CITY OF ALBUQUERQUE

**RE: Country Club Plaza Bldg 3
1718 Central SW, Suite D
Revised Grading Plan Stamp Date: 6/6/18
Drainage Report Stamp Date: 12/8/17
Hydrology File: J13D010**

Based on the information provided in your submittal received on 6/6/18, the revised grading plan cannot be approved for Building Permit or SO-19 until the following are corrected:

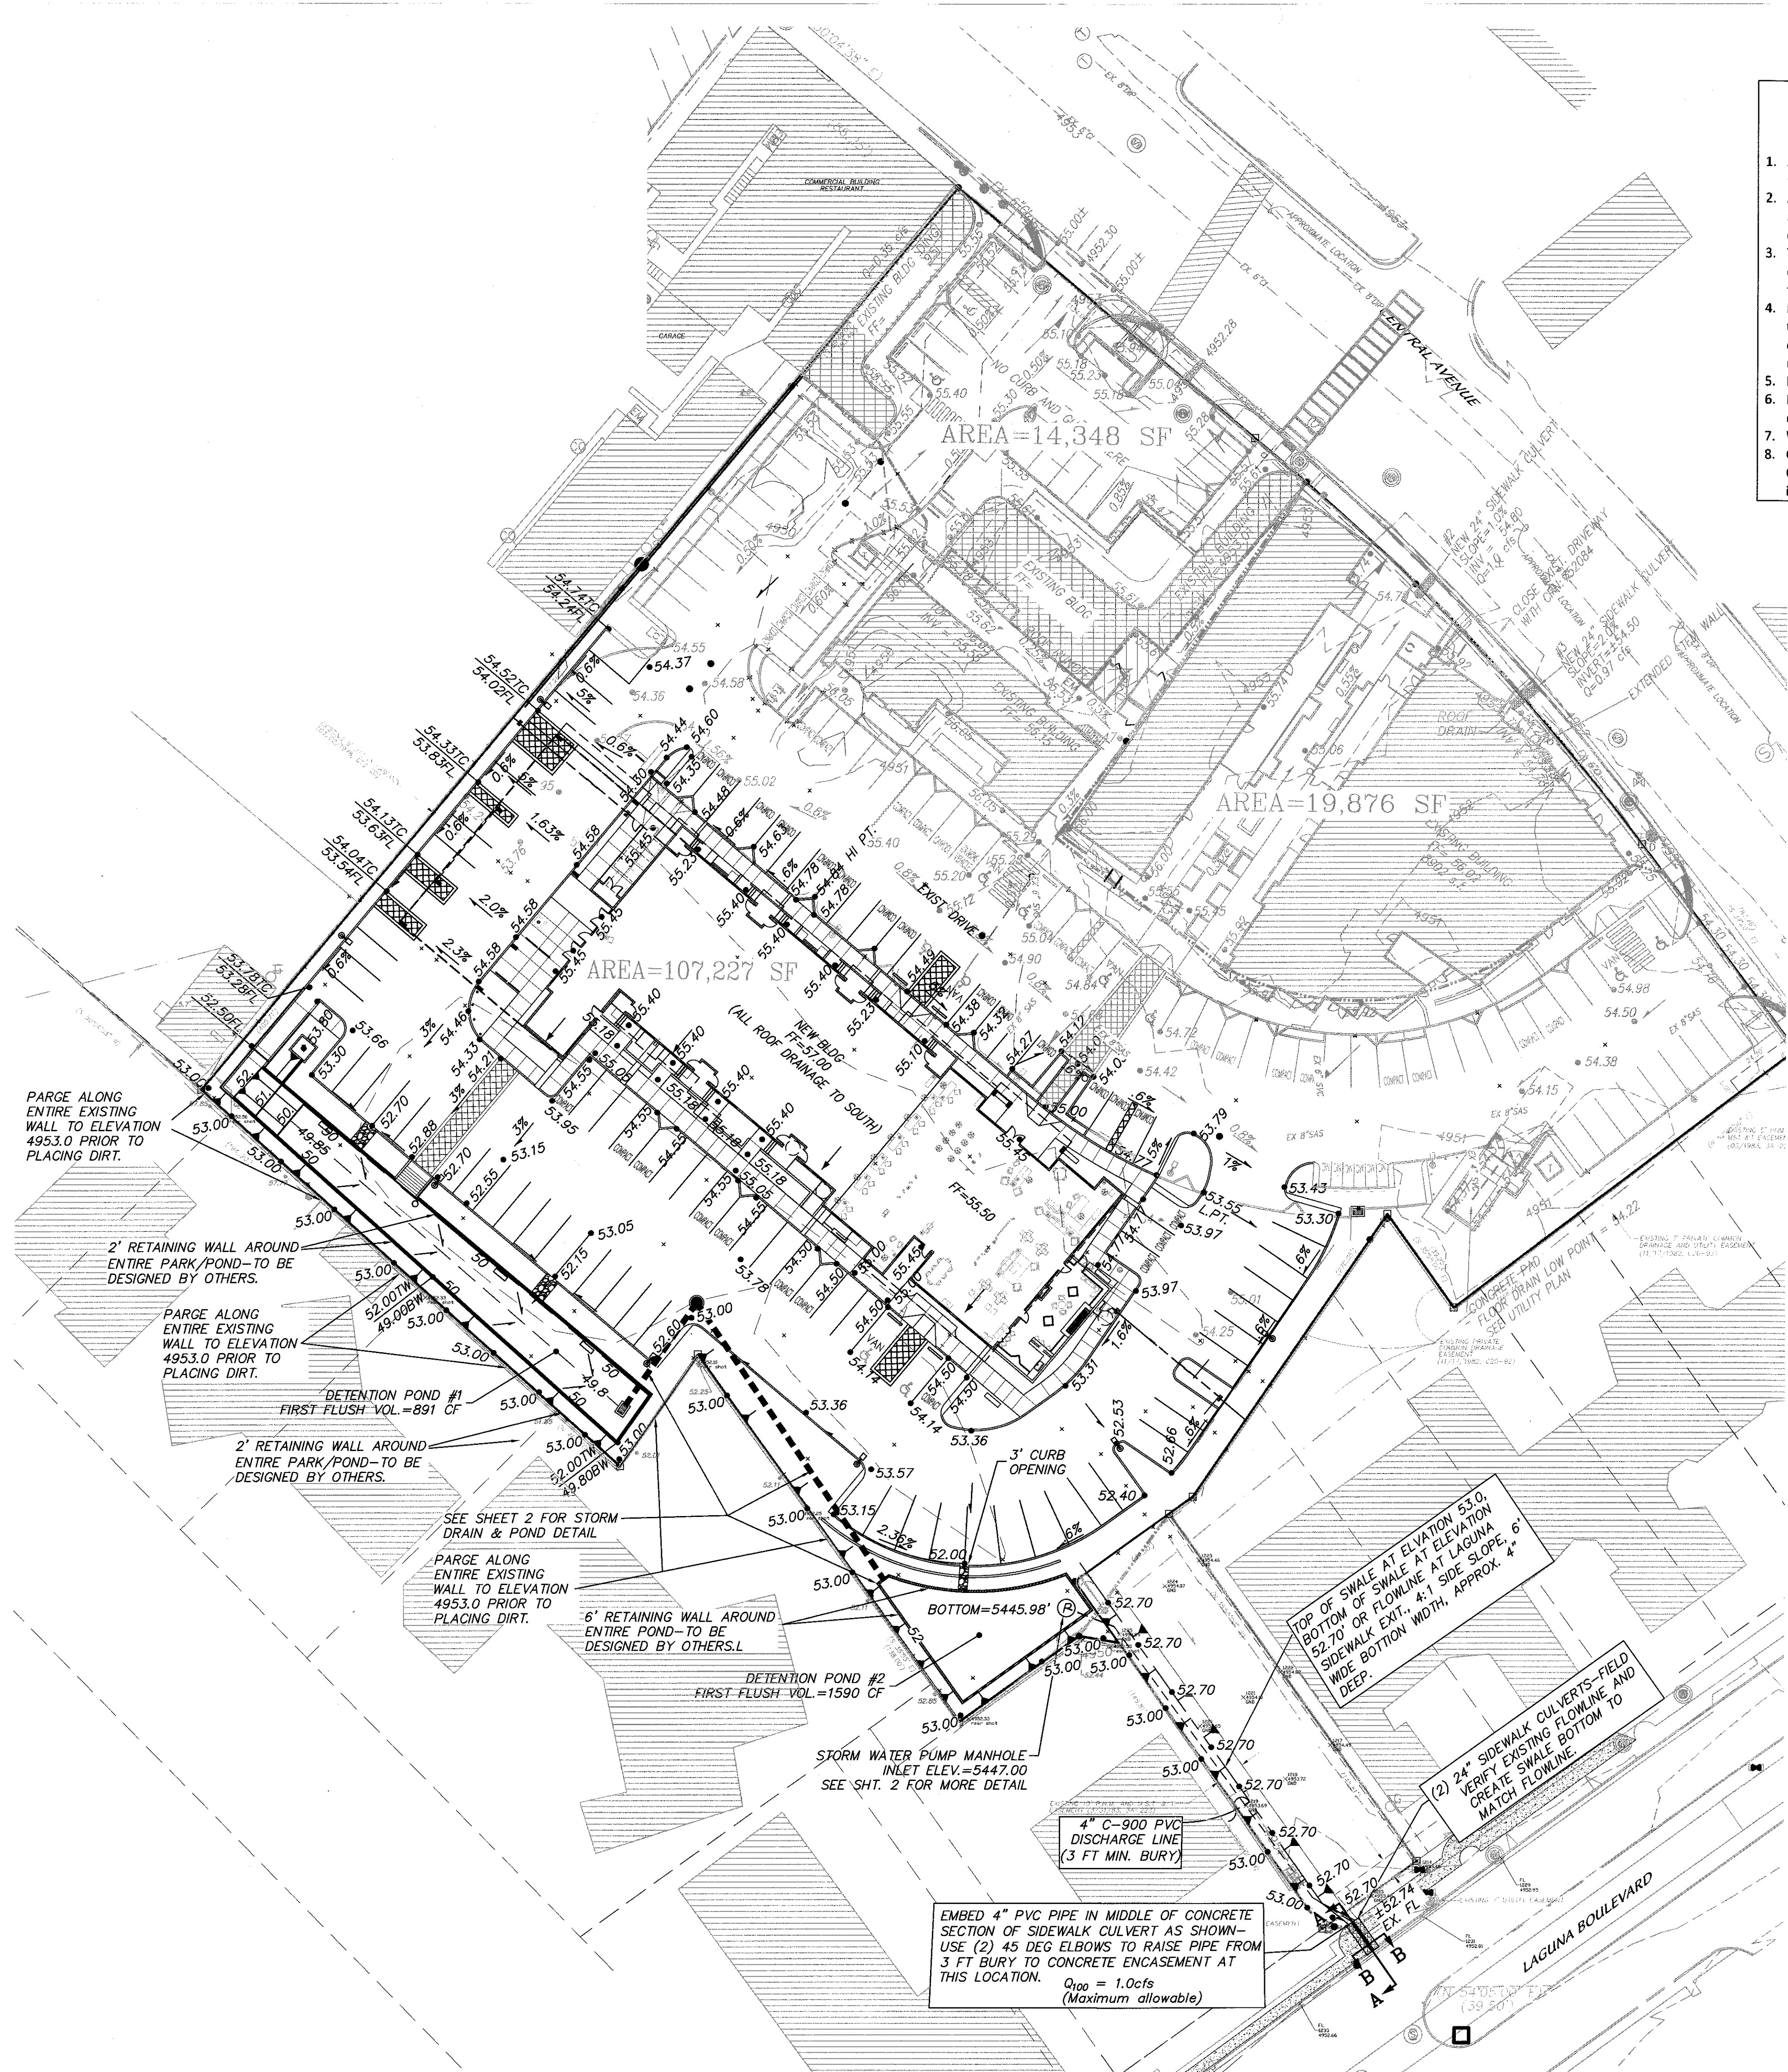
1. Provide a detail for the proposed stubout into the sidewalk culvert. Include the ROW line and dimensional data; a vermin-exclusion cover is recommended. Ensure that the stubout doesn't interfere with pedestrian or vehicle traffic or the functionality of the sidewalk culvert. Also call-out std dwg 2236 for the sidewalk culvert construction.
